PLANNING CONSULTATION RESPONSE

Application No	2026/0406
Proposal	2026 0406 New Dwelling on Land Adjacent to 1 Kensington Avenue Thurlstone
Address	1 Kensington Ave Thurlstone
Date of Consultation Reply	040826
Consultee	Tony Wiles Senior Conservation Officer

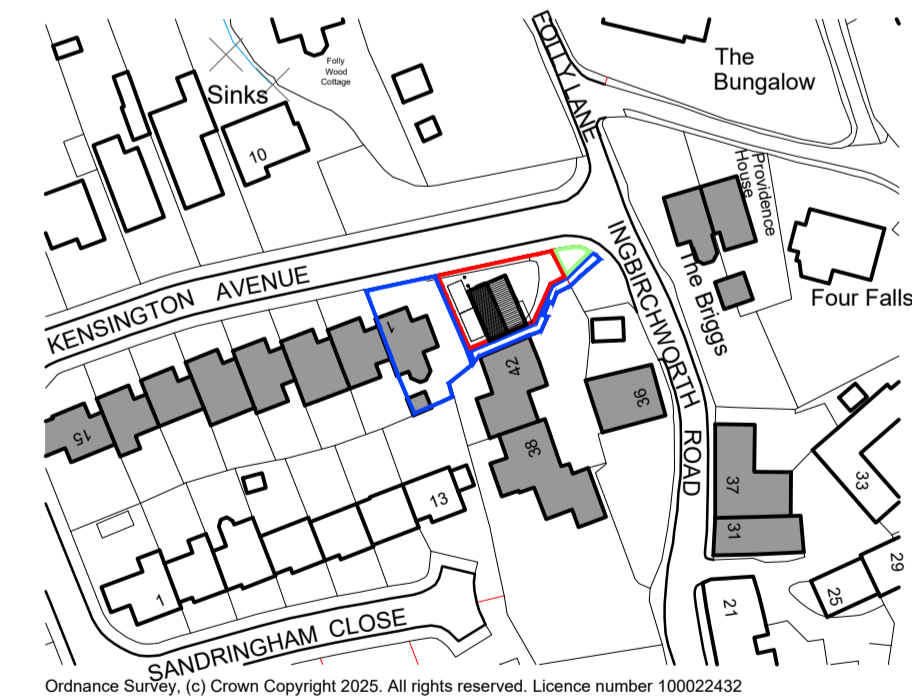
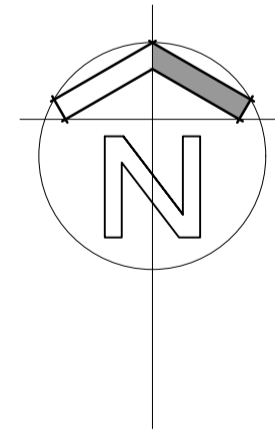
The submitted plans have been revised from the sketch scheme previously reviewed. The proposed house type is broadly comparable in form, scale and massing to No. 1 Kensington Avenue, and the design is relatively restrained rather than overblown. Overall, I do not consider the proposal to represent overdevelopment of the plot. However, although the footprint is modest, the western elevation of the proposed dwelling appears to extend marginally forward of the western/front building line of No. 42 Ingbirchworth Road. I would therefore request a minor repositioning of the dwelling within the plot, so that the western elevation of the new building does not project forward of the principal elevation/building line of No. 42 Ingbirchworth Road.

At this stage I have indicated that the proposal should be deferred for amendments. However, if the minor repositioning or reduction in footprint can be accommodated, I consider that the scheme could accord with Section 72(1) of the Planning (Listed Buildings and Conservation Areas) Act 1990, Local Plan Policy HE1 and paragraph 212 of the NPPF. On that basis, I would be willing to support the proposal subject to the minor amendment identified above.

Drawing Title	Proposed Plans and Elevations
Ground and First Floor

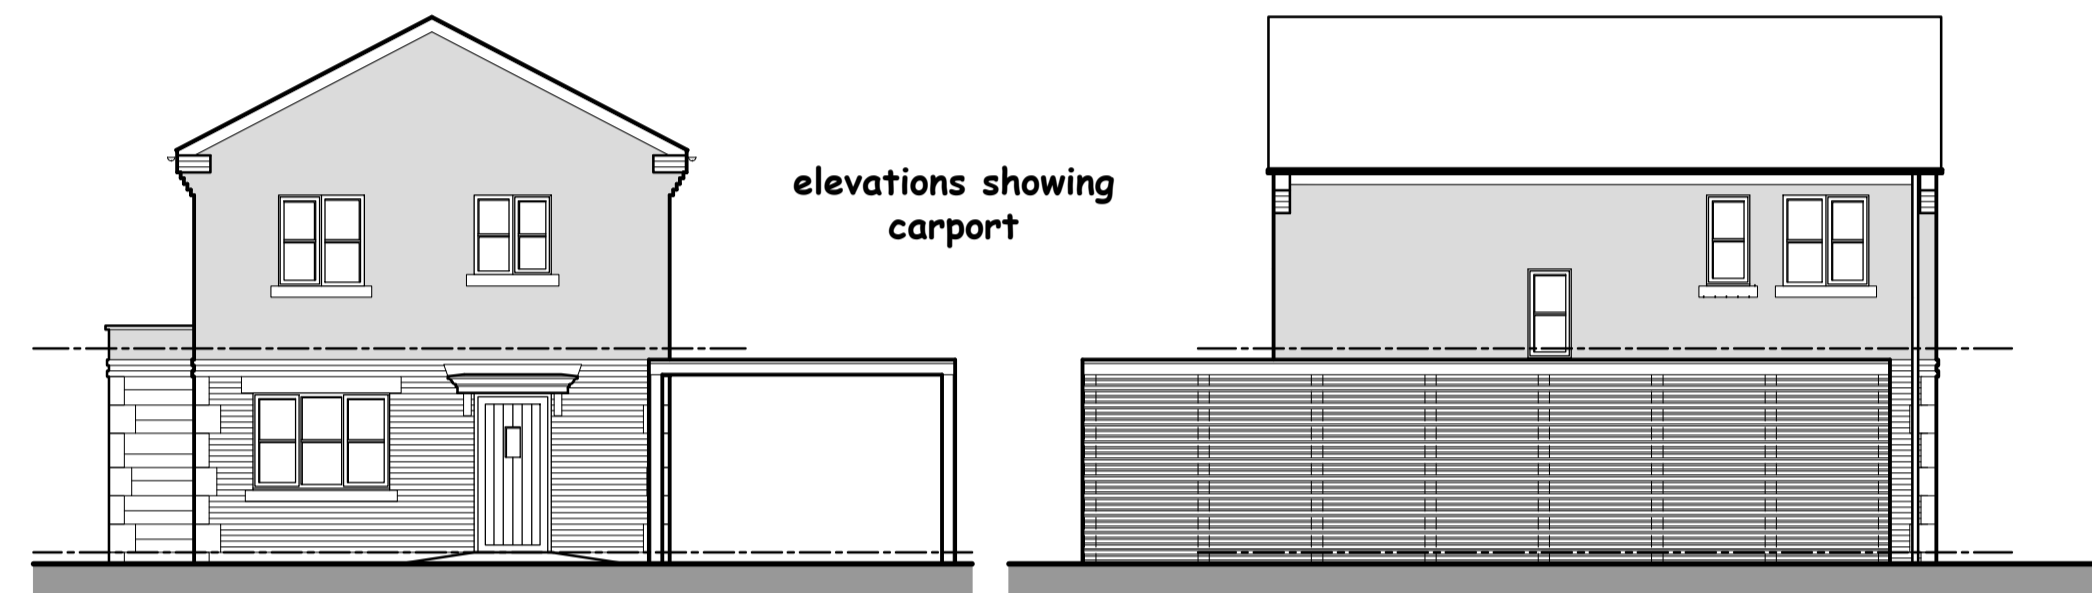
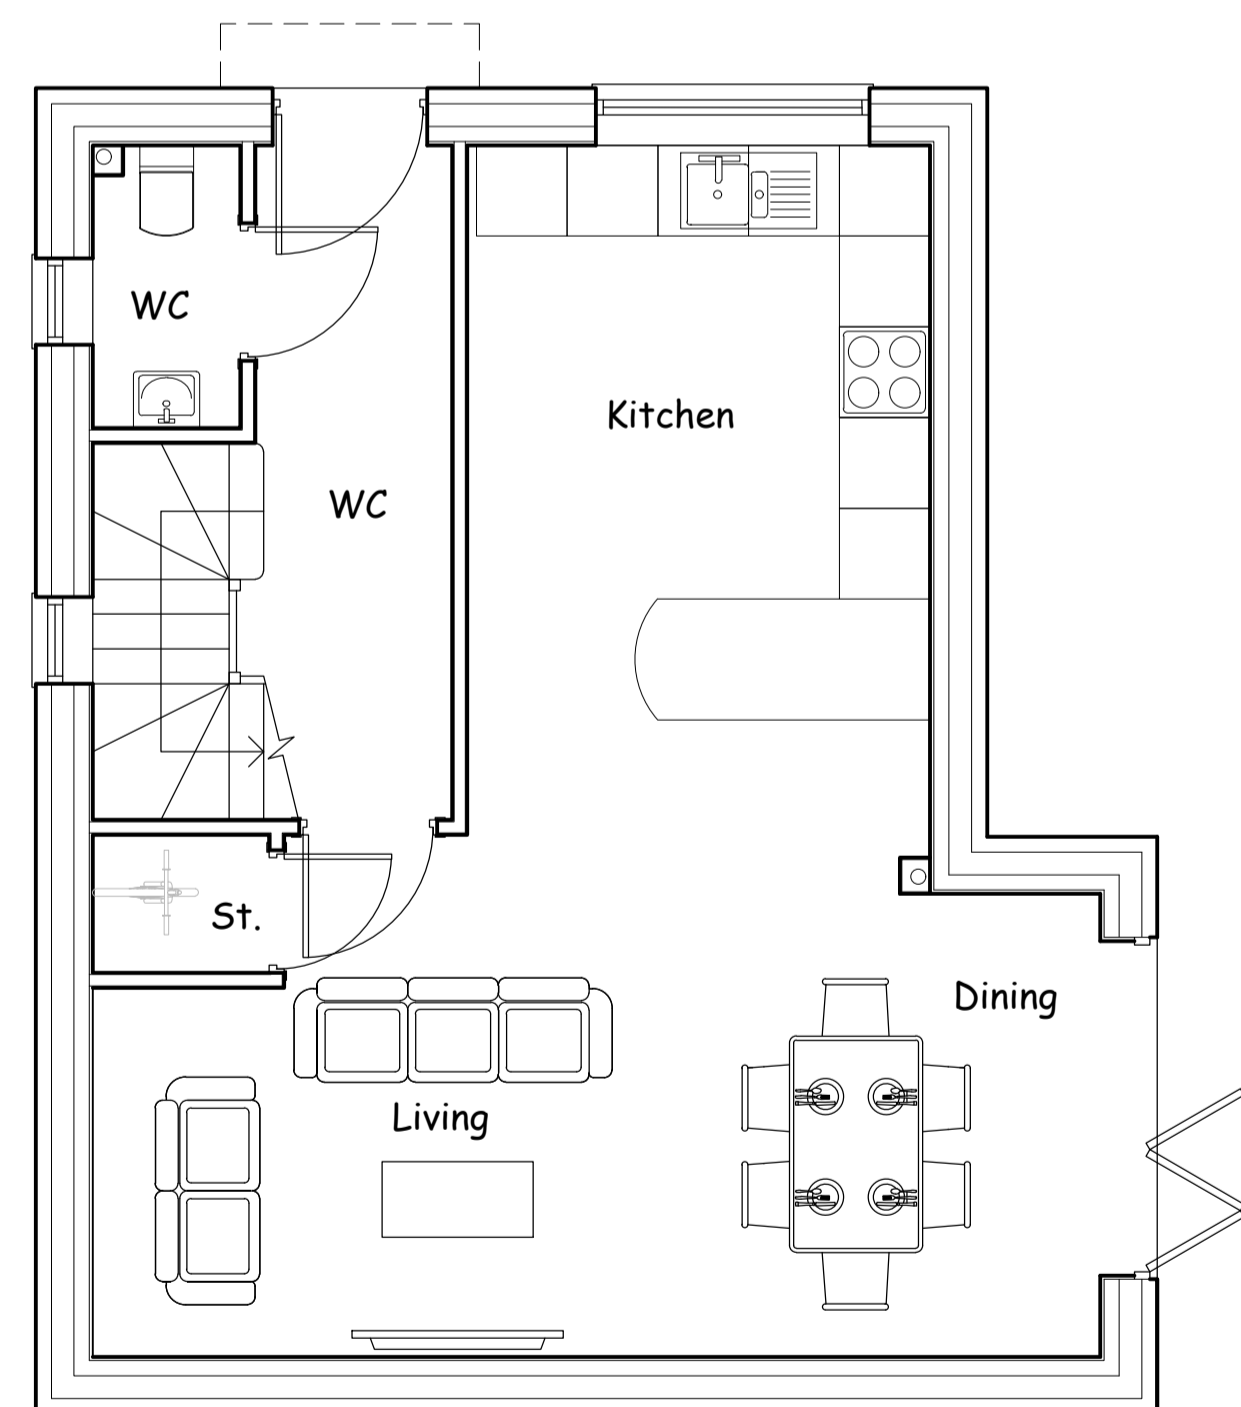
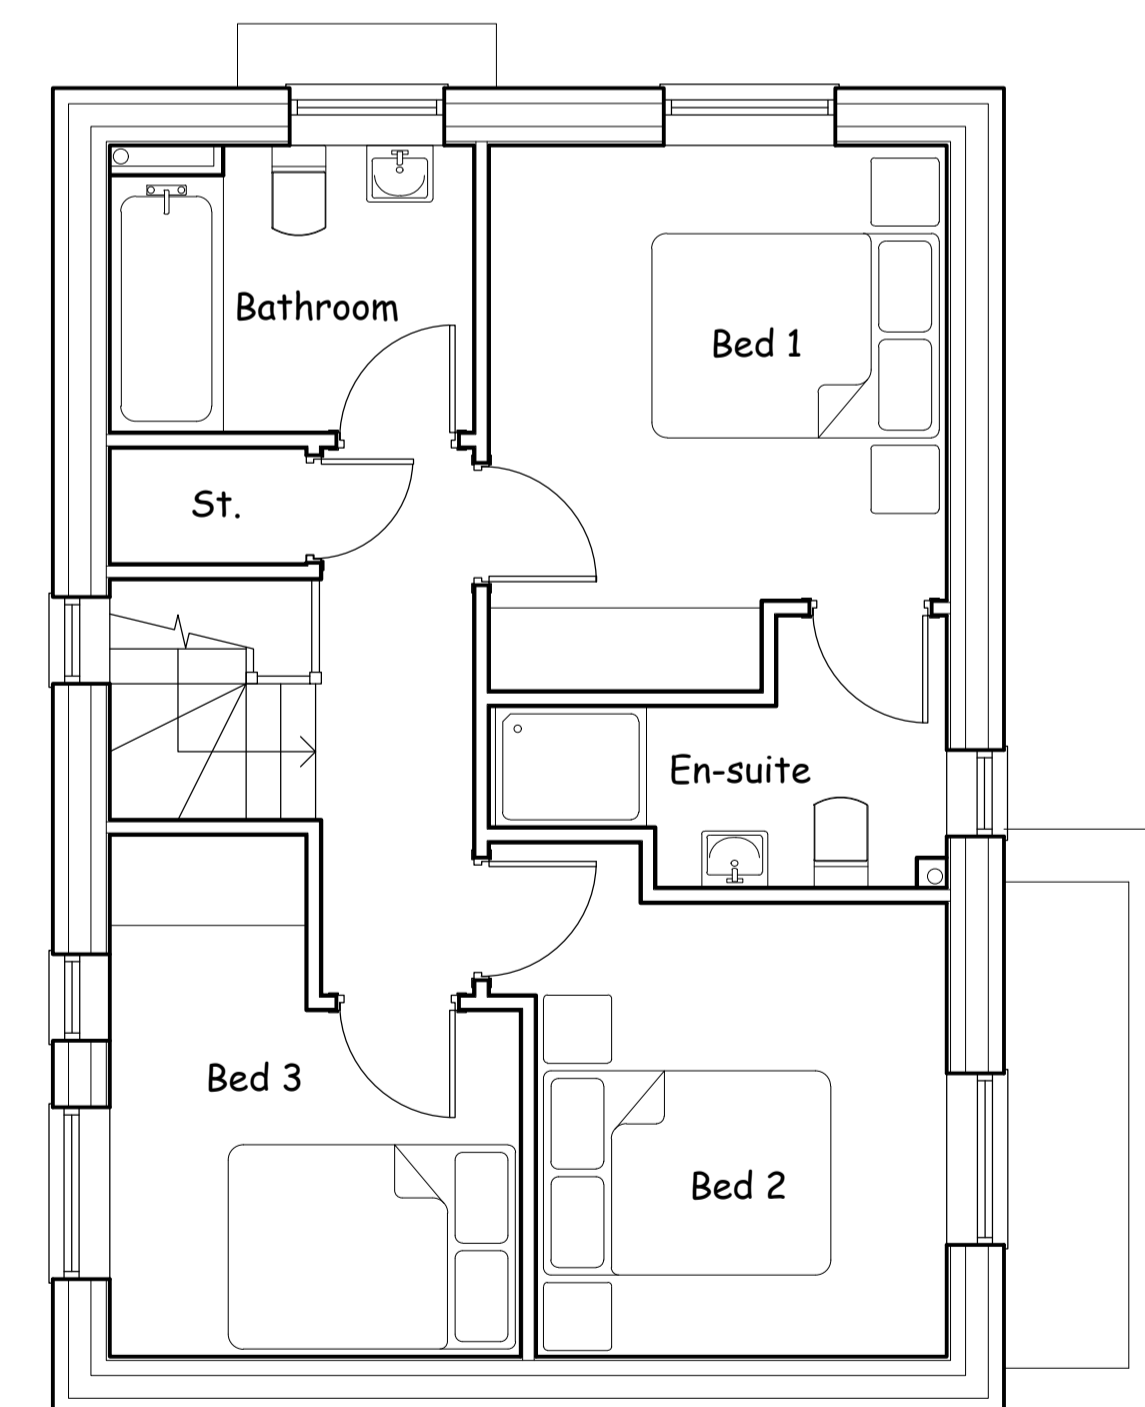
In terms of mitigation, the use of stone and render on the southern elevation will help to soften the appearance of the new dwelling and better relate it to its surroundings. I also note the proposed hedge planting, which would help contain and filter views of the development from the junction of Kensington Avenue and Ingbirchworth Road, particularly from the west. Subject to the minor repositioning requested above, I consider that the overall impact of the proposal would be appropriately minimised and mitigated, and that the development would not result in harm to the setting of the conservation area.
